Application for removal or variation of a condition following grant of
 planning permission. Town and Country Planning Act 1990.
 Planning (Listed Buildings and Conservation Areas) Act 1990

Conversion of redundant health facility in to 14 dwellings and erection of 18 terraced dwellings complete with parking facilities .

Proposed plan Drawing number IDHH/OR/11/003 to be changed to IDHH/OR/11/003 REV A

Drawing Title: PROPOSED PLANS

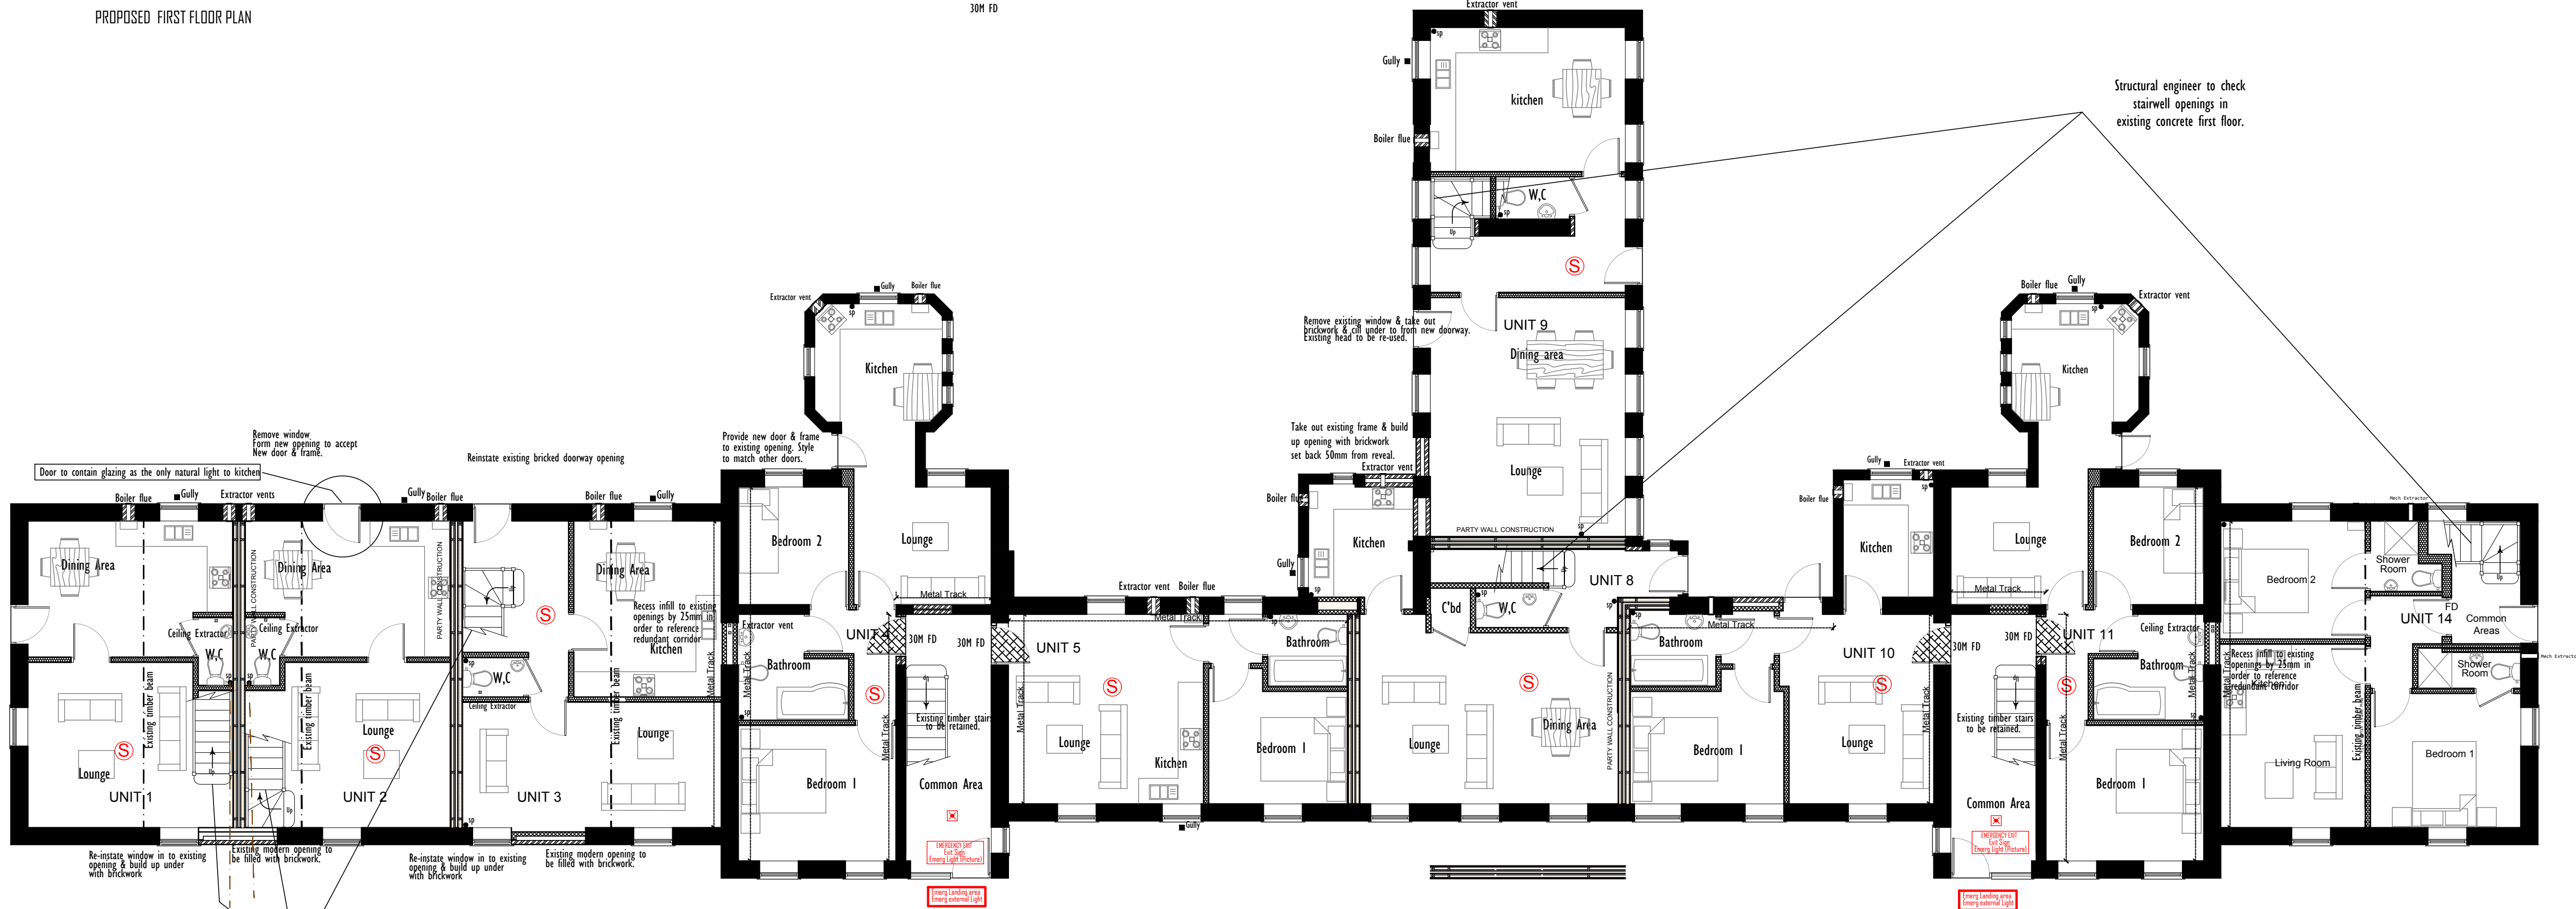
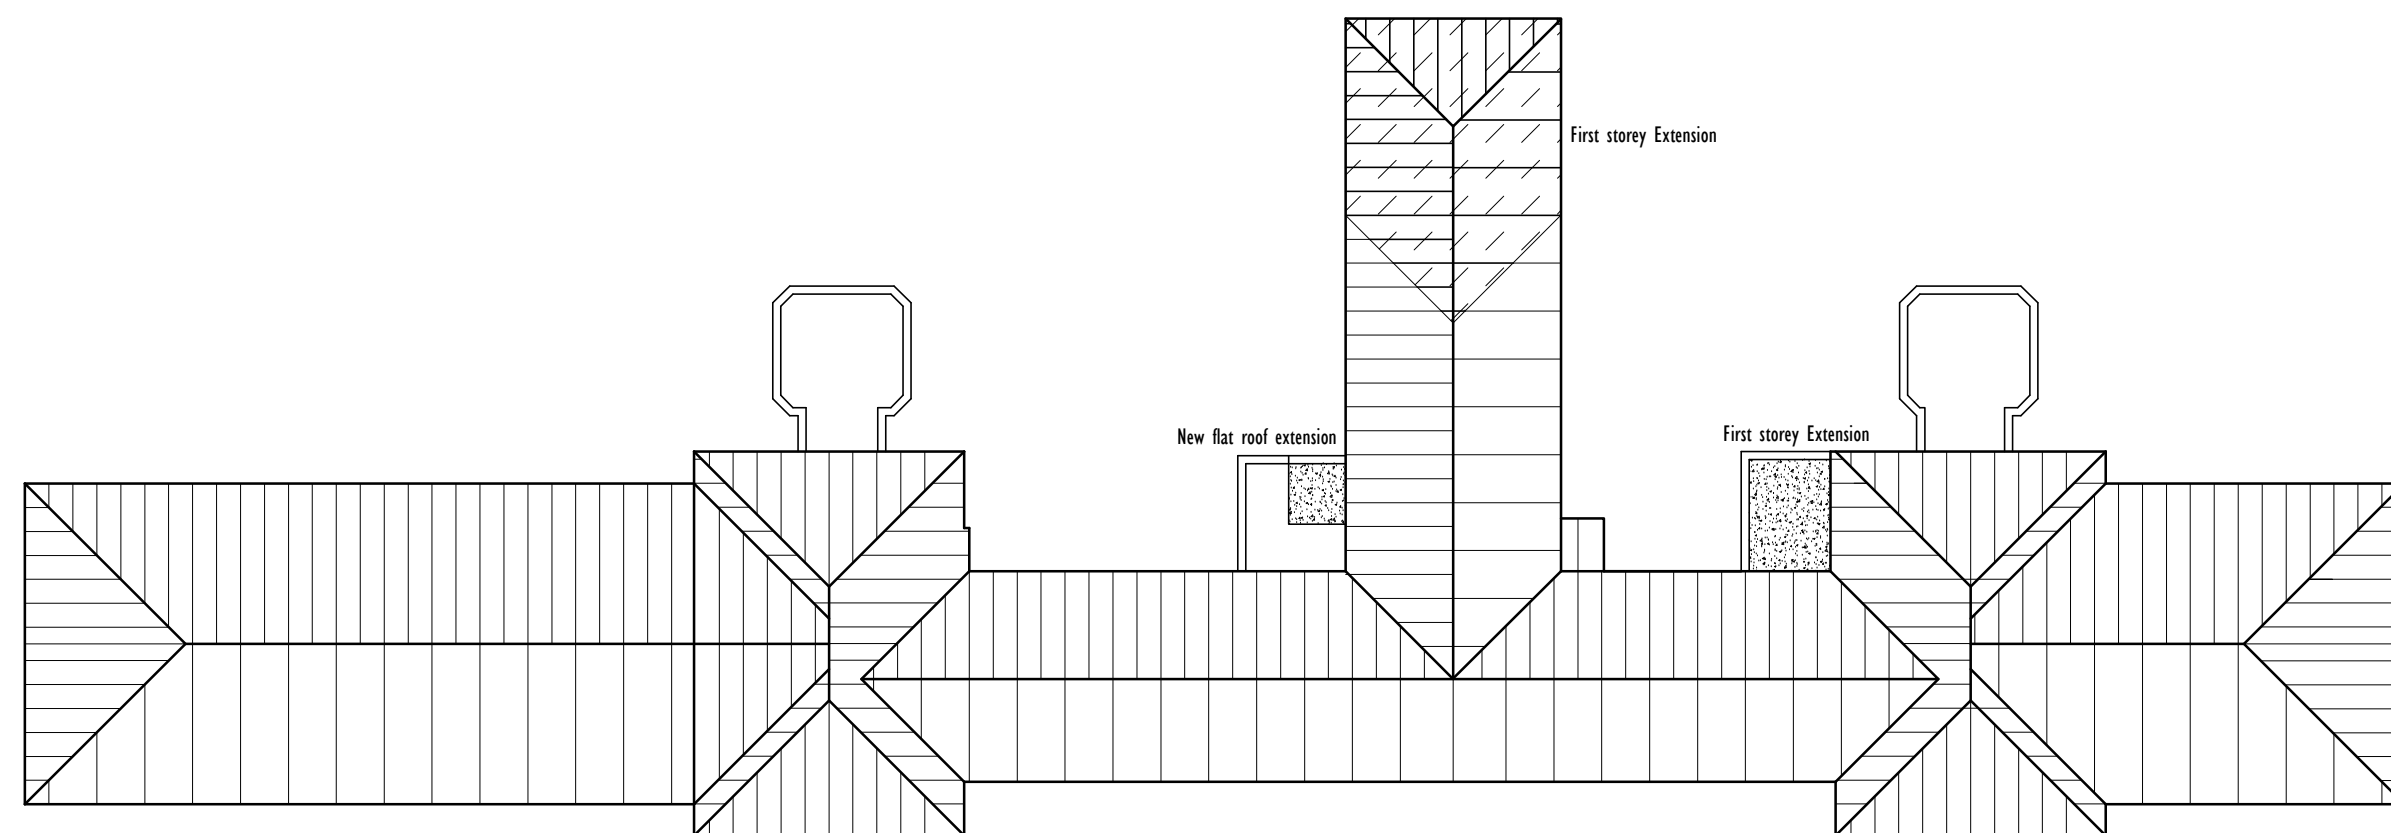
The applicant wishes to revise the proposed layout of the scheme to create two apartments in the area currently denoted as unit 14 (postal address Number 1 Orchard house) .

Unit 14 would be revised to incorporate a 1 bedroom apartment on the ground floor and another 1 bedroom apartment on the first floor.

The ground floor apartment could retain the postal address number 1 and the first floor apartment could become 1A.
